## Accessibility Review Report – DA Review

**Project Title:** IC3 West Data Centre  
17-23 Talavera Road, Macquarie Park

**Date:** 22 October 2021

**Report Version:** 21302\_ADR\_DA\_v1.2

GENERAL ARRANGEMENT GROUND FLOOR

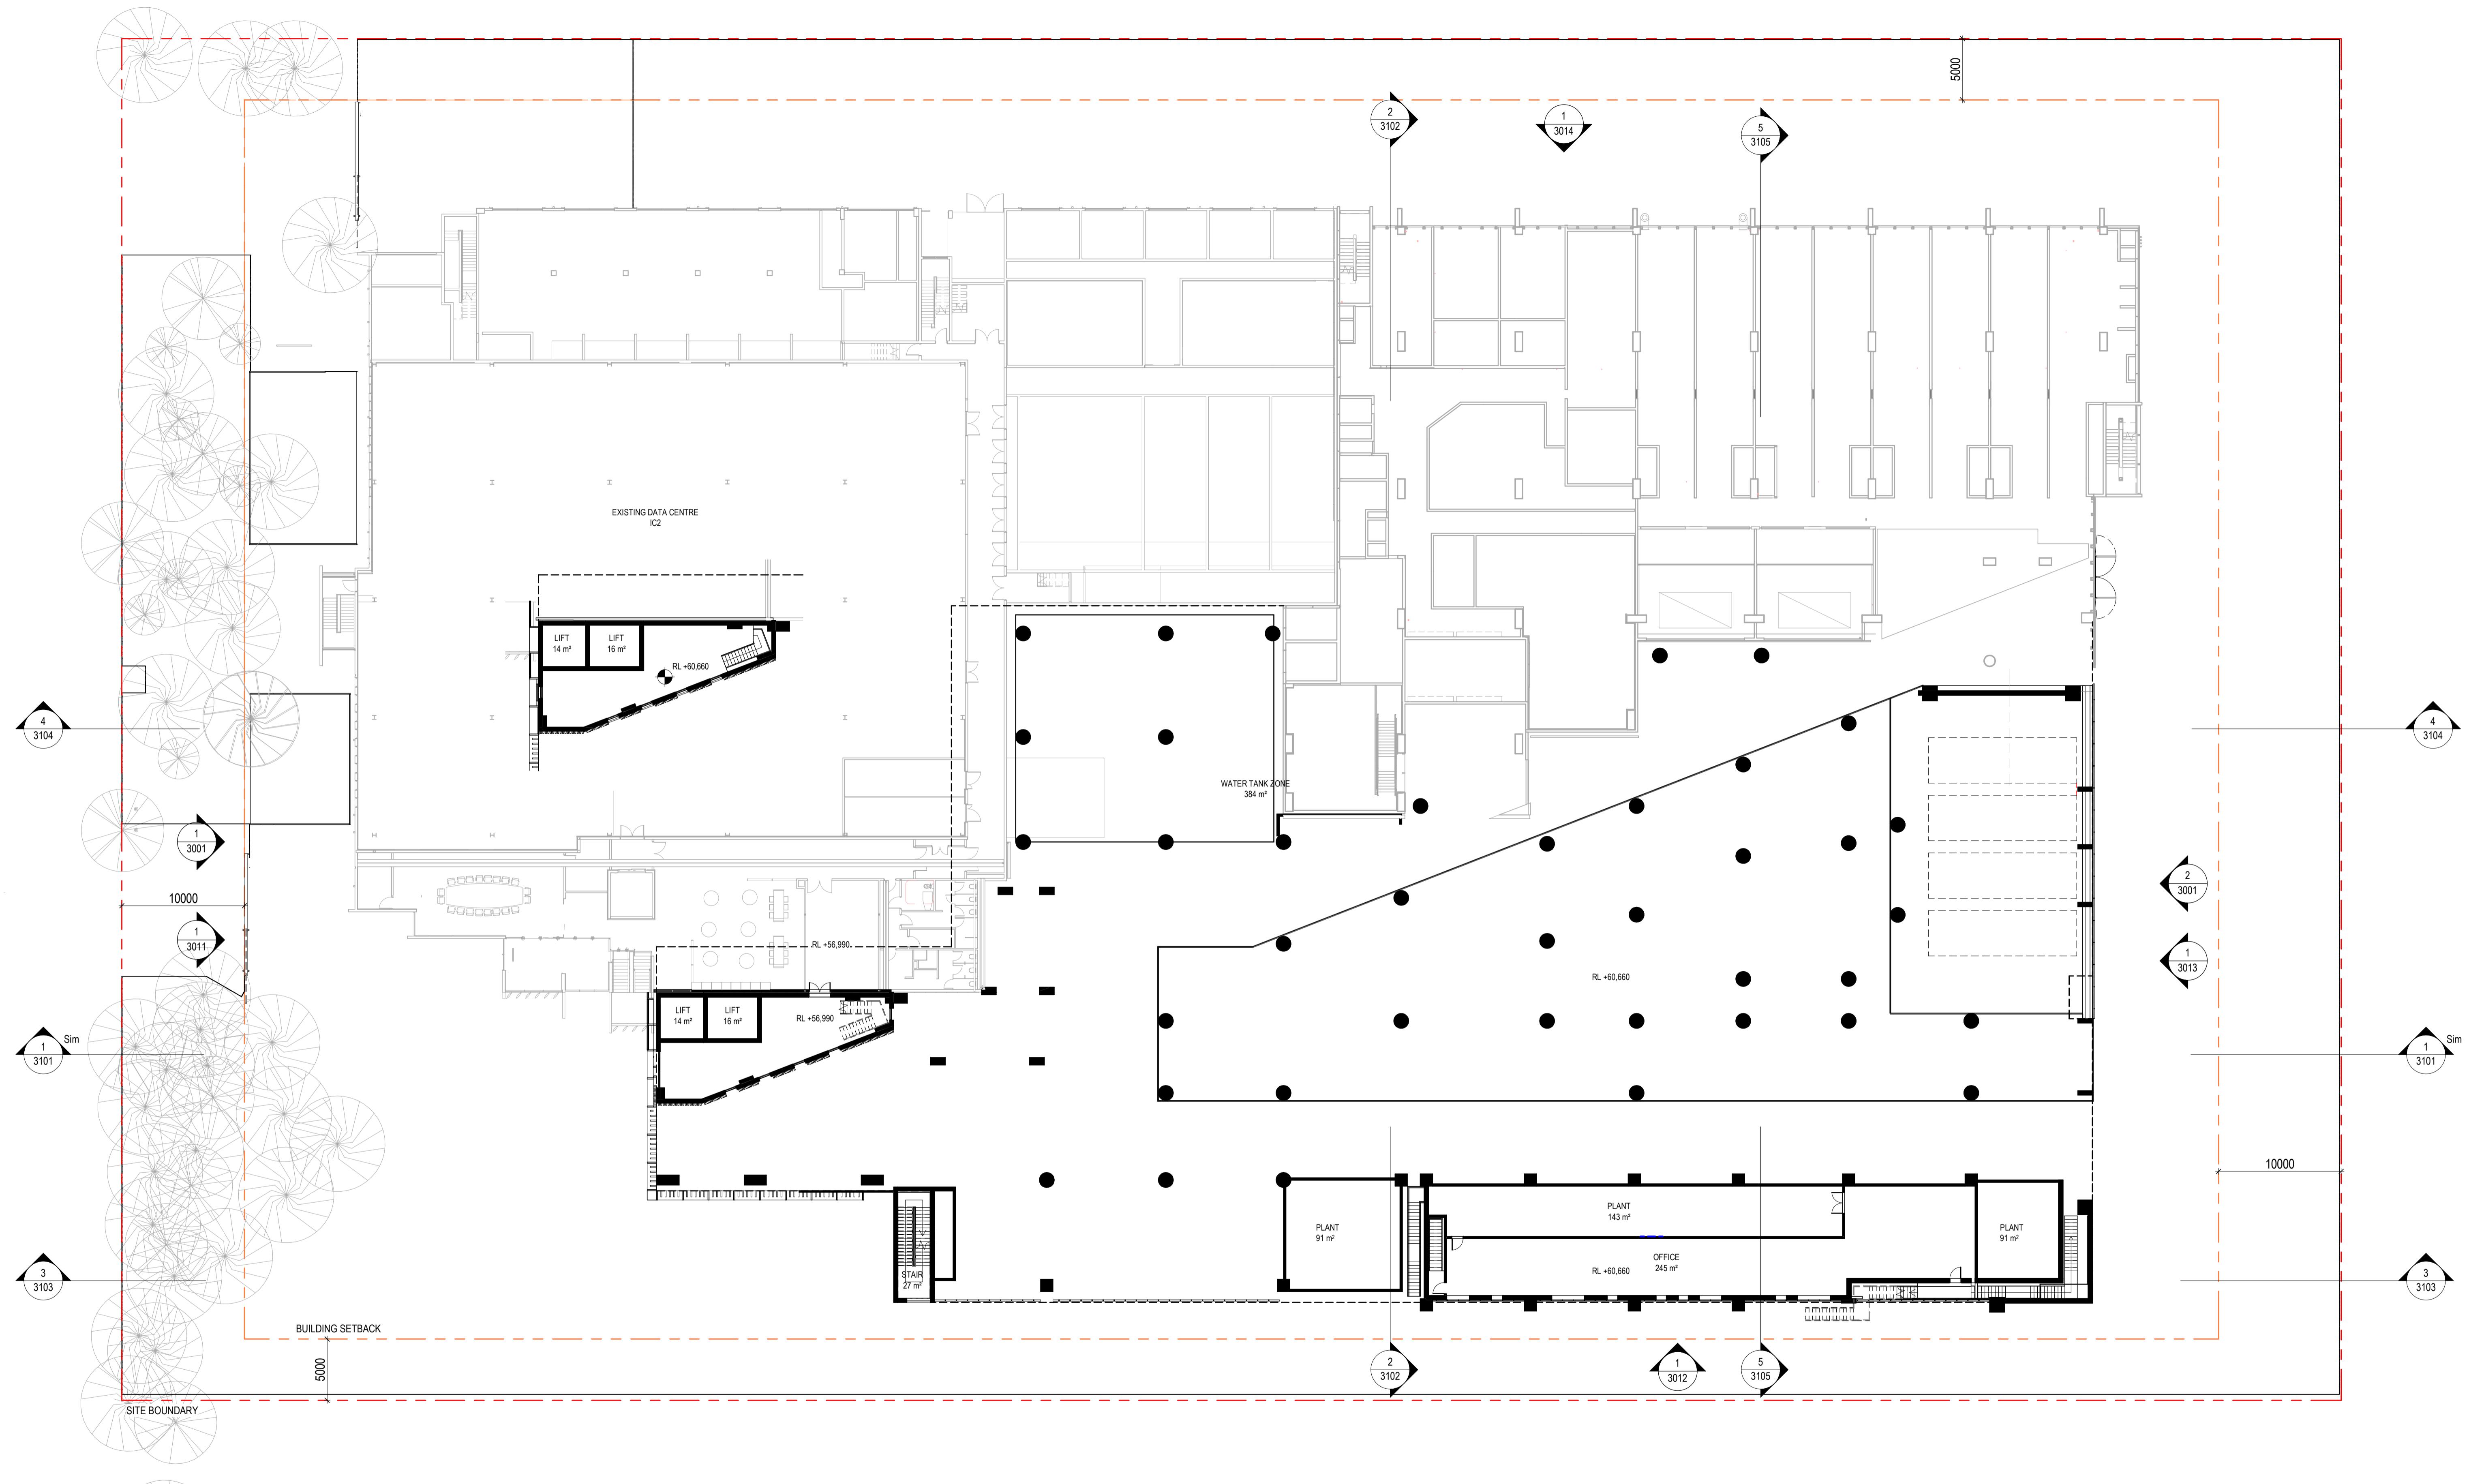
<b>DtS Provision</b>	<b>Comment(s)/Recommendation(s)</b>	<b>Status</b>
<p>An accessway must be provided to a building required to be accessible –</p> <ul style="list-style-type: none"> <li>from the main points of pedestrian entry at the allotment boundary; and</li> <li>from another accessible building connected by a pedestrian link; and</li> <li>from any required accessible carparking space on the allotment.</li> </ul> <p>In a building required to be accessible, an accessway must be provided through the principal pedestrian entrance, and –</p> <ul style="list-style-type: none"> <li>through not less than 50% of all pedestrian entrances including the principal pedestrian entrance; and</li> <li>in a building with a floor area more than 500m<sup>2</sup>, a pedestrian entrance which is not accessible must not be located more than 50m from an accessible pedestrian entrance.</li> </ul> <p>except for pedestrian entrances serving only areas exempted by D3.4.</p>	<p>The following pathway is proposed –</p> <ul style="list-style-type: none"> <li><b>1x</b> main point of pedestrian entrance to the building from Talavera Road indicated by a green arrow below. Dotted green line indicates the path of travel to the Principal Pedestrian Entry (PPE) from the boundary.</li> </ul>  <p><u>Compliance Departure(s) –</u></p> <p>A compliant accessway is not provided from the main point of pedestrian entrance at the allotment boundary and via the PPE indicated by the red arrows below –</p>	DD

The accessway via the PPE to the new passenger lifts is required to comply with BCA and AS1428.1-2009 due to the “affected part” provisions in the Premises Standard. An audit will need to be completed to verify compliance and address the following key issues:

- Access via the PPE (i.e. doorway design/details, door hardware, visual indicators etc.).
- Access through the existing security gates (gate width and card reader locations).
- Access via the existing corridors and doorways leading to the new passenger lifts.

<p>The following will need to be detailed at the design development stage:</p> <ul style="list-style-type: none"> <li>• Ensure access via the PPE complies with AS1428.1-2009.</li> <li>• Access via the security gates is to allow for a compliant 1m path of travel and swipe card readers at the prescribed locations.</li> <li>• Doorways to achieve an 850mm clear opening width and circulation as prescribed by AS1428.1-2009.</li> <li>• Doorway design including hardware, opening force and contrast to comply with AS1428.1-2009.</li> <li>• Consecutive doorways along an accessway must achieve a 1450mm clear space between the doors.</li> <li>• Travel via the existing corridors and doorways to comply with AS1428.1-2009.</li> </ul>	
--	---	--

- The proposed compliance departure is proposed to be addressed via a Performance Solution. This is to be determined on a case-by-case basis and will require further development / discussion at the detailed design stage.
